SUBJECT: Engineering Review Comment
Mountain View Electric Association Inc. (MVEA)

Project Name: Flying Horse North Filing 4 – Final Plat
Project Number: SF2422

Description: Proposed development of 48 residential lots and 9 tracts located west of Black Forest Rd. and south of Hodgen Rd. in Township 11S, Range 66W, Section 36 and Township 11S, Range 65W, Sections 30 and 31.

A PORTION OF THE NORTHEAST QUARTER OF SECTION 36, TOWNSHIP 11 SOUTH, RANGE 66 WEST,  
A PORTION OF THE SOUTH HALF OF SECTION 30, AND A PORTION OF THE NORTH HALF OF SECTION 31,  
TOWNSHIP 11 SOUTH, RANGE 65 WEST OF THE SIXTH PRINCIPAL MERIDIAN

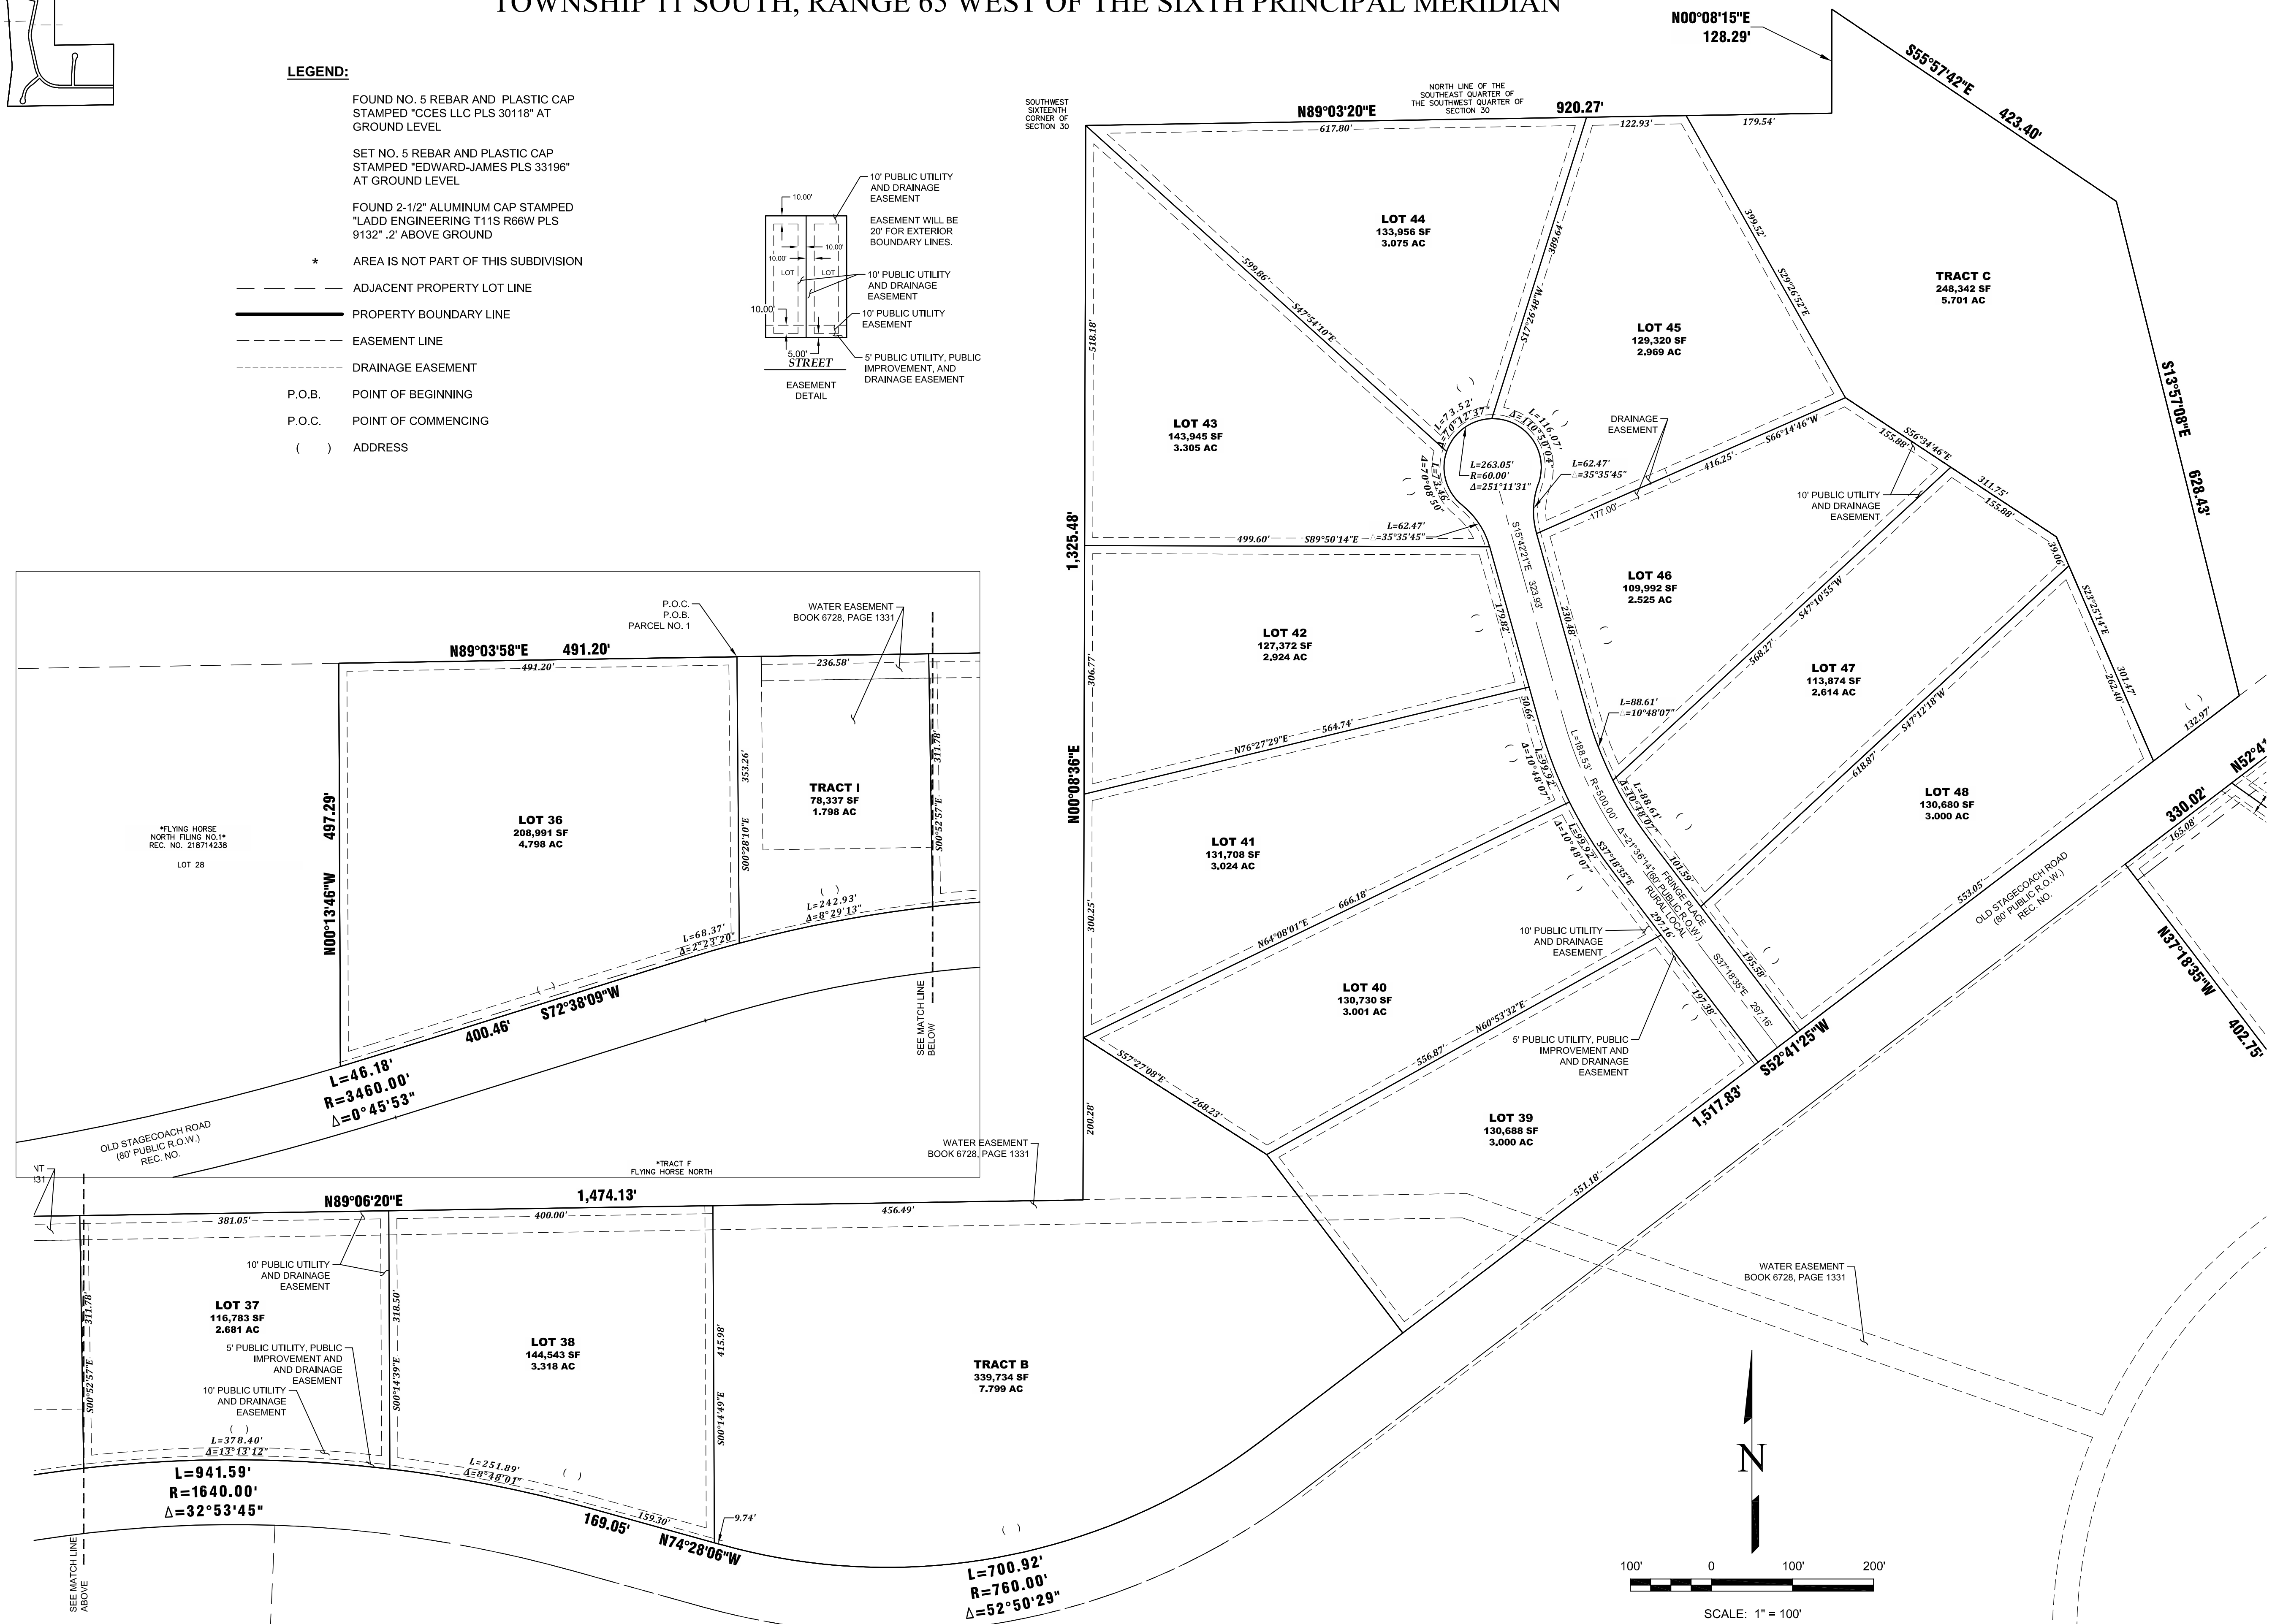
MVEA requests a ten (10) foot front, side, and rear lot utility easement and all tracts, in addition to any public improvement easement, along with a twenty (20) foot exterior utility easement on the plat. MVEA also requests the platting of MVEA's existing facilities with easements on the plat. Additional easements may be required.
